Re: PA22-010, Sunnyside Nursery Expansion

MEMORANDUM

RE: Sunnyside Nursery Expansion, File# PA22-010
Nursery Expansion including storm, landscape and parking lot improvements.
3915 Sunnyside Blvd & Parcel #'s 29050300106100, 29050300101200, 29050300106000

SUBJECT: PA 22-010 – Sunnyside Nursery Expansion

SUNNYSIDE SOUTH PRELIMINARY SITE PLAN

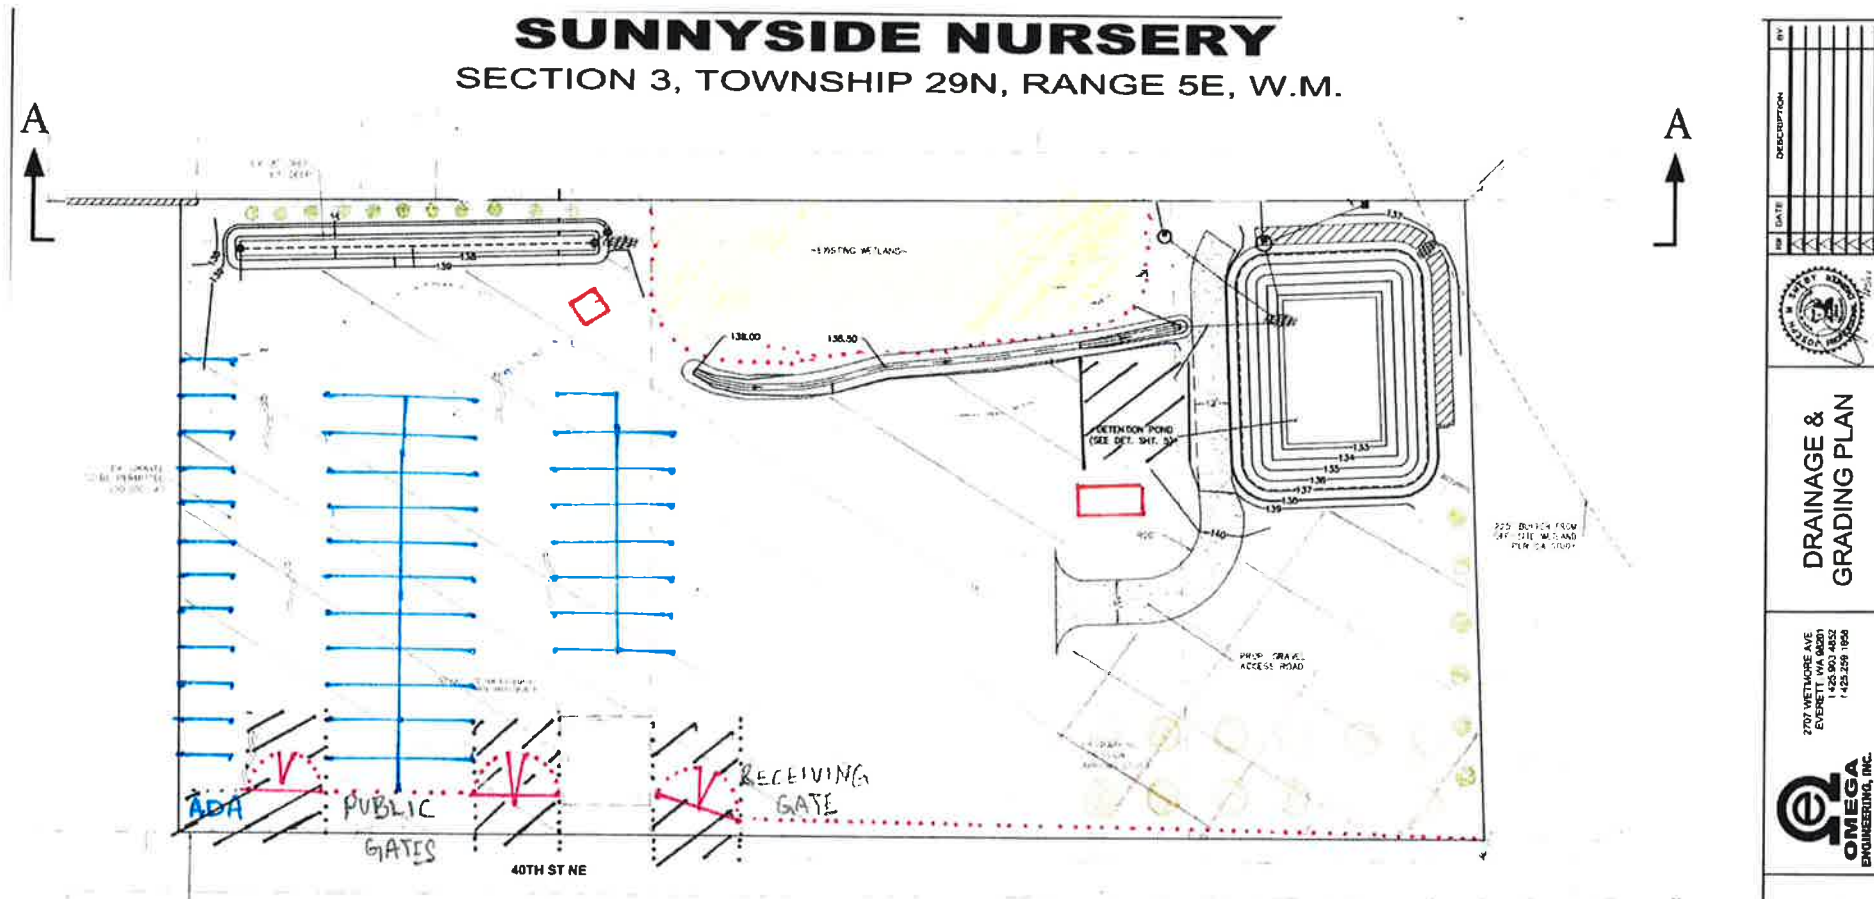
Provide a *single*, legible site plan drawn utilizing a common engineering scale (e.g., one inch equals 20 feet, one inch equals 30 feet, one inch equals 40 feet) depicting the following elements:

- (1) The proposed/existing buildings and appurtenances;
- (2) Locations, size, shape and design of the parking spaces;
- (3) Existing/proposed curb cuts or access locations
- (4) Existing/proposed illumination;
- (5) Landscaping areas and method of irrigation; show the landscaping areas now – a detailed landscape plan including spacing and species may be deferred to civil plan submittal.
- (6) Parking lot circulation (i.e., drive aisles, turning radii, etc.);
- (7) Storage areas (recommend identifying areas where plants will be stored versus other storage elements; plants do not need to be screened but other storage areas do);
- (8) Drainage facilities;

(9) Wetland, buffer enhancement area, materials storage areas, limits of paved surfaces and types of pavement, dumpsters, fences, or any other feature of the site.

- For the storage area, a 5 foot landscape buffer is required between the outdoor storage area and the street frontage.
- For the parking area, 15-foot wide, Type L3 landscaping buffer is required between the parking area and 40th Street NE. The width of these buffers may be reduced by 25 percent where a berm at least three feet in height or a fence at least six feet in height is incorporated into the landscaping, and the landscaping is incorporated elsewhere on site.

- Show the landscape screening buffer around any outdoor storage (for example pallets, dumpster, etc.) with a five-foot wide 'Type L1' landscape buffer, or a six-foot tall sight-obscuring fence or masonry wall five feet inside the property line with a 'Type L2' buffer between the fence/wall and the property line as required by MMC Sections 22C.120.120 & 22C.120.160. The pallets, dumpster, and racks along the north property line will need to be screened. The overall landscape material does not need to be screened. A five-foot wide 'Type L1' landscape buffer, or a six-foot tall solid masonry wall or sight-obscuring fence five feet inside the property line with a 'Type L2' buffer between the fence or wall and the property line, will need to be installed around any outside storage or waste areas pursuant to MMC Sections 22C.120.120 & 22C.120.160. Storage areas are prohibited within 15 feet of the street lot line. Solid waste containers are required to be placed on a concrete pad per the Solid Waste Division's specifications.

3) **Prior to civil construction plan approval**, amend the plans to show the required protective curbing where vehicles will be adjacent to landscaping. All perimeter and interior landscaped areas must have cast in place or extruded protective curbs along the edges. Curbs separating landscaped areas from parking areas may allow storm water runoff to pass through them. Tire stops, bollards or other protective barriers may be used at the front ends of parking spaces. Curbs may be perforated or have gaps or breaks. Trees must have adequate protection from car doors as well as car bumpers.

EXISTING BASIN MAP
SUNNYSIDE NURSERY

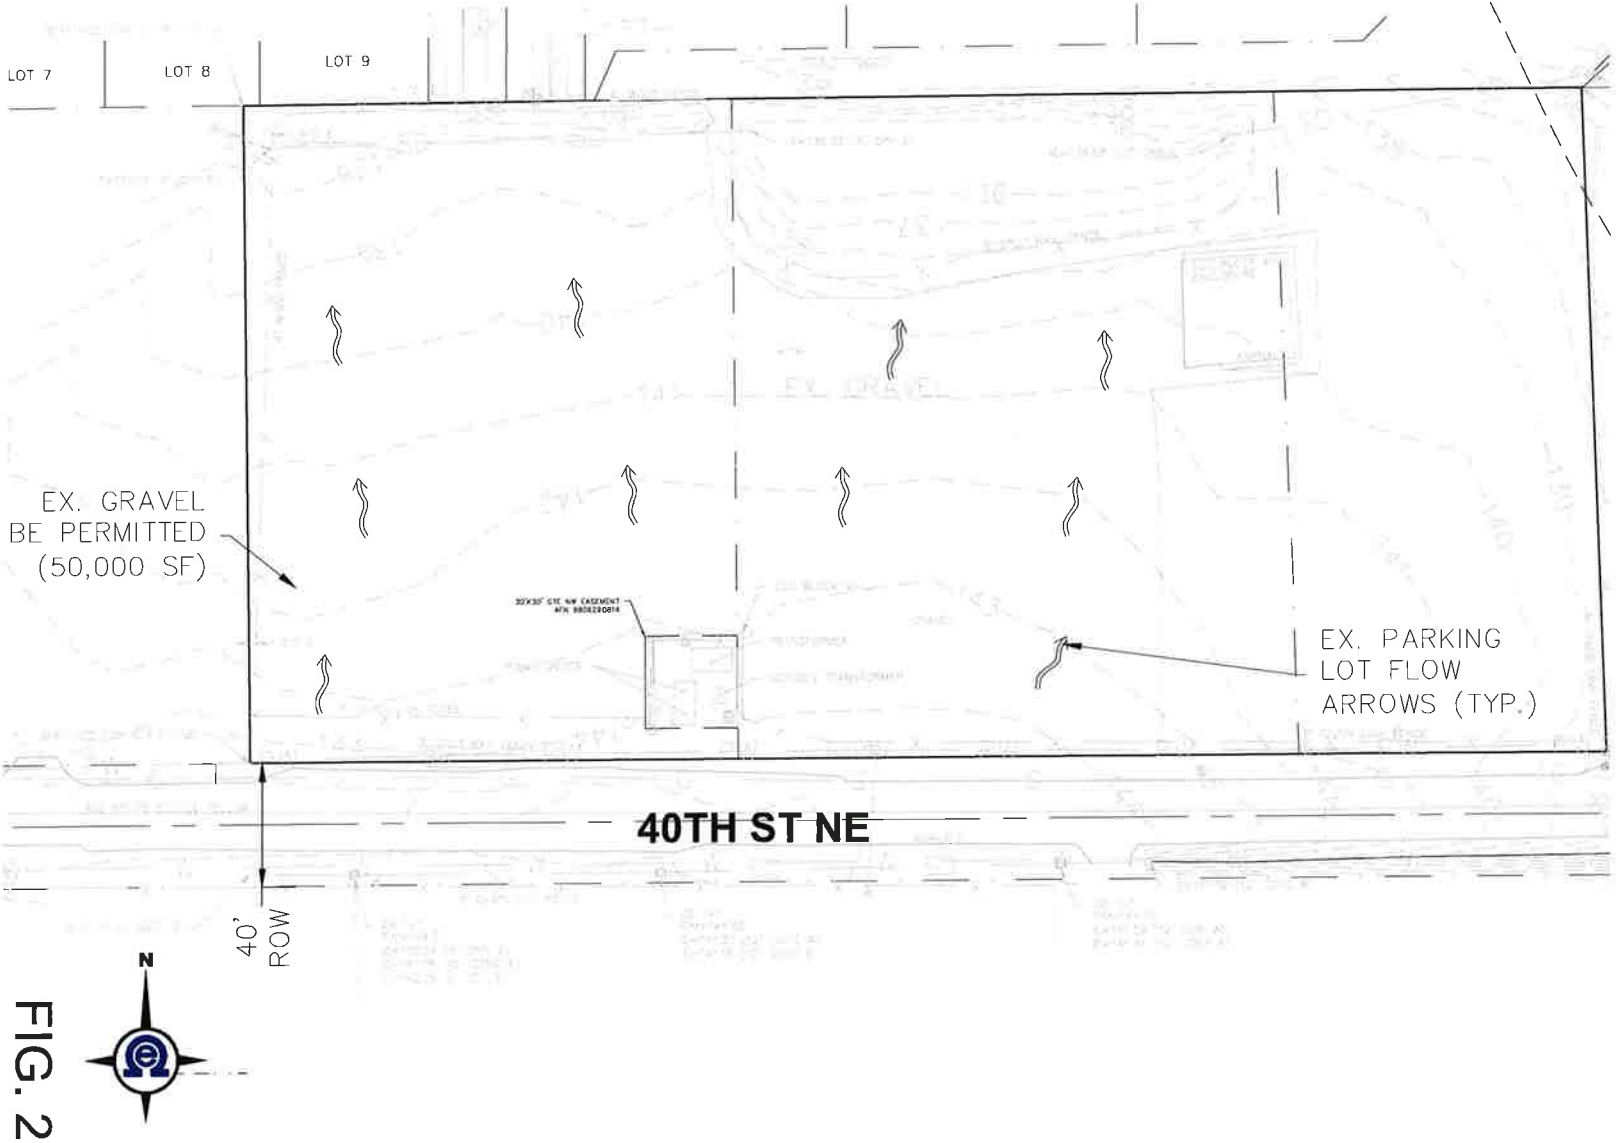
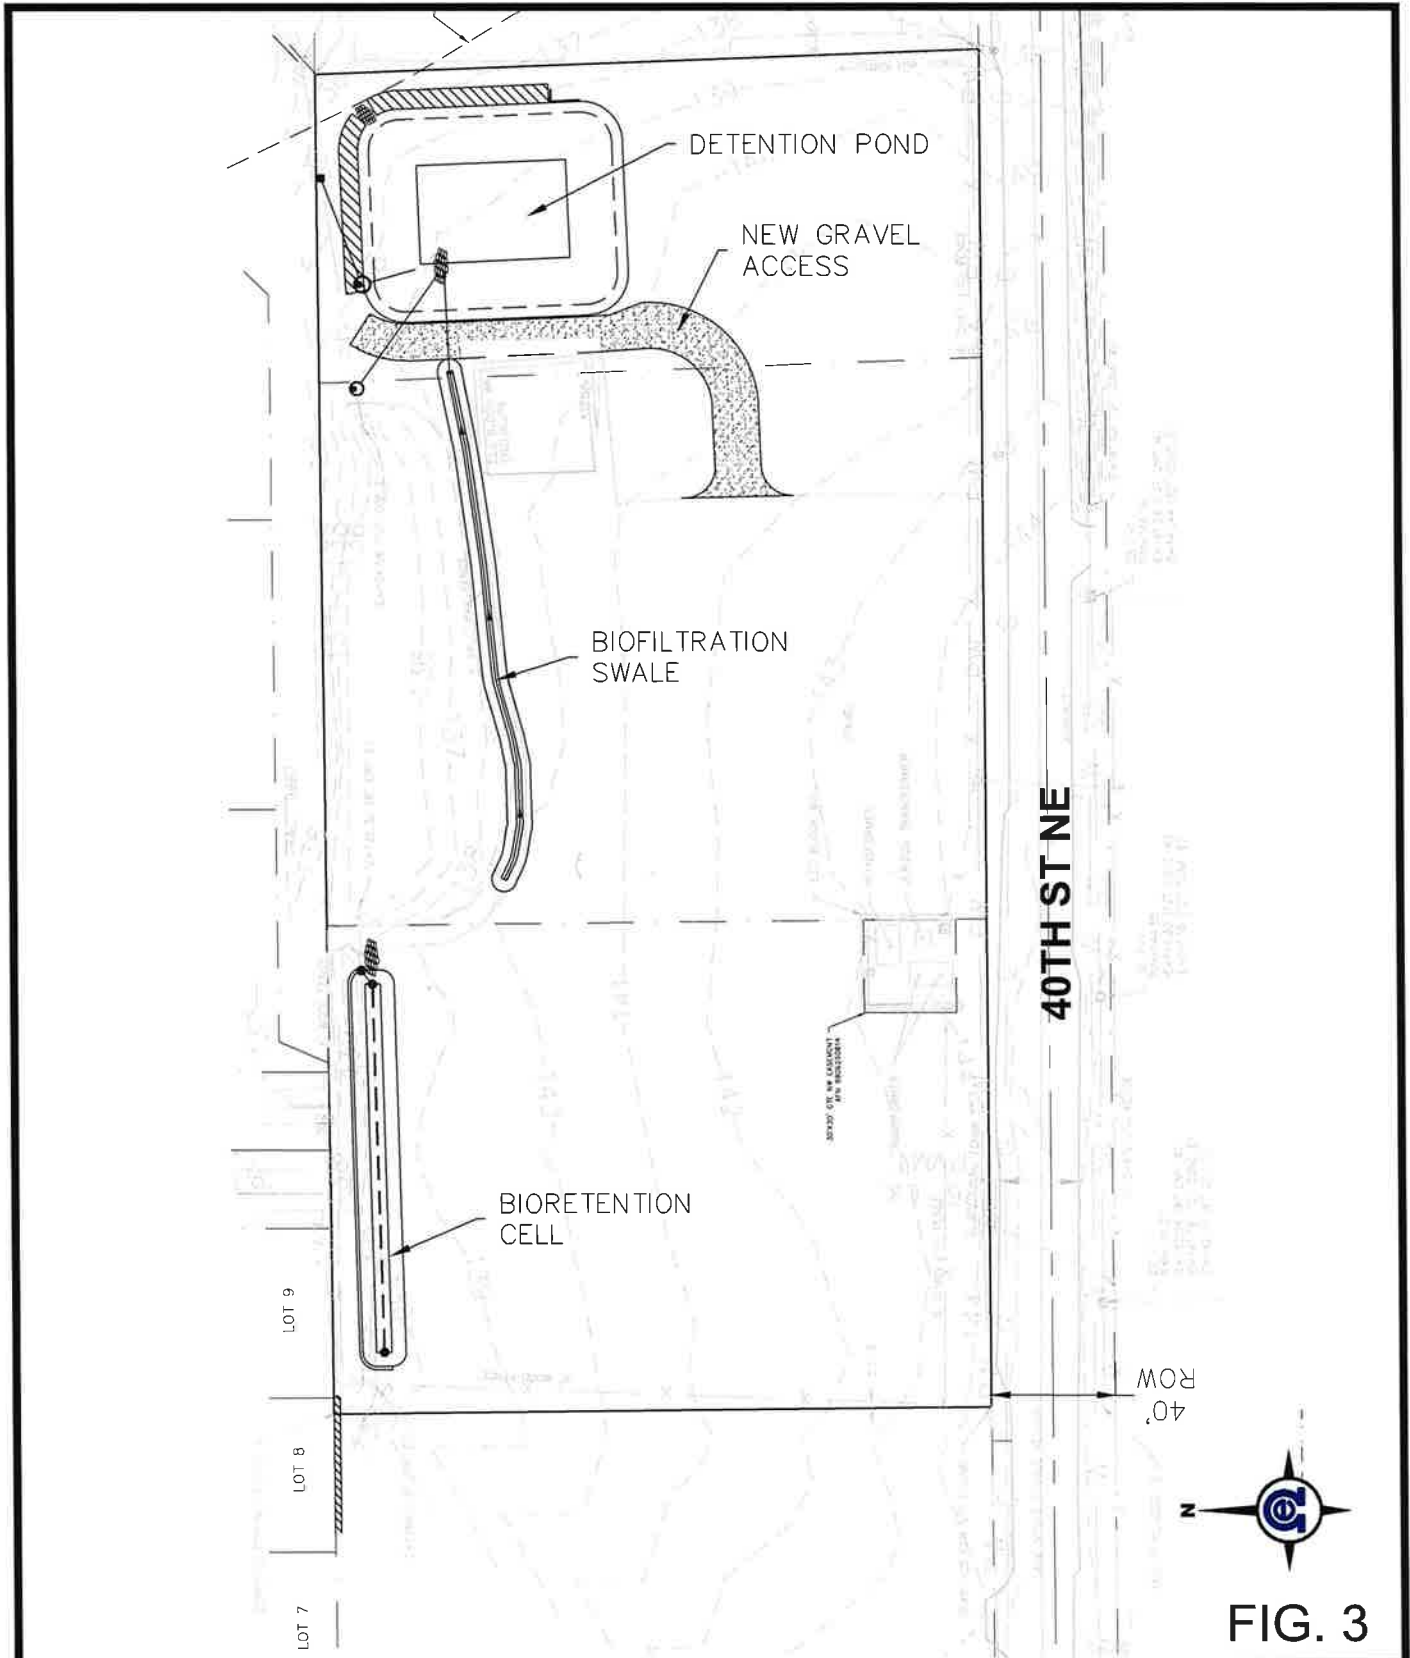
6. **Drainage:** All projects in the city of Marysville must comply with requirements stipulated under the MMC 14.15.040 and 14.15.050.
 - a. Stormwater drainage: The city has adopted the 2012 Ecology Manual as amended in 2014. Projects above the 2,000 square feet threshold must comply with requirements stipulated in Volume I, Chapter 2 of the Stormwater Management Manual for Western Washington.
 - i. The modeling needs to reflect a predeveloped condition of forested, not forested and lawn for basin 1. Also, not sure why the pond is reflected in the predeveloped conditions.
 - ii. Please include a basin map in the next submittal.
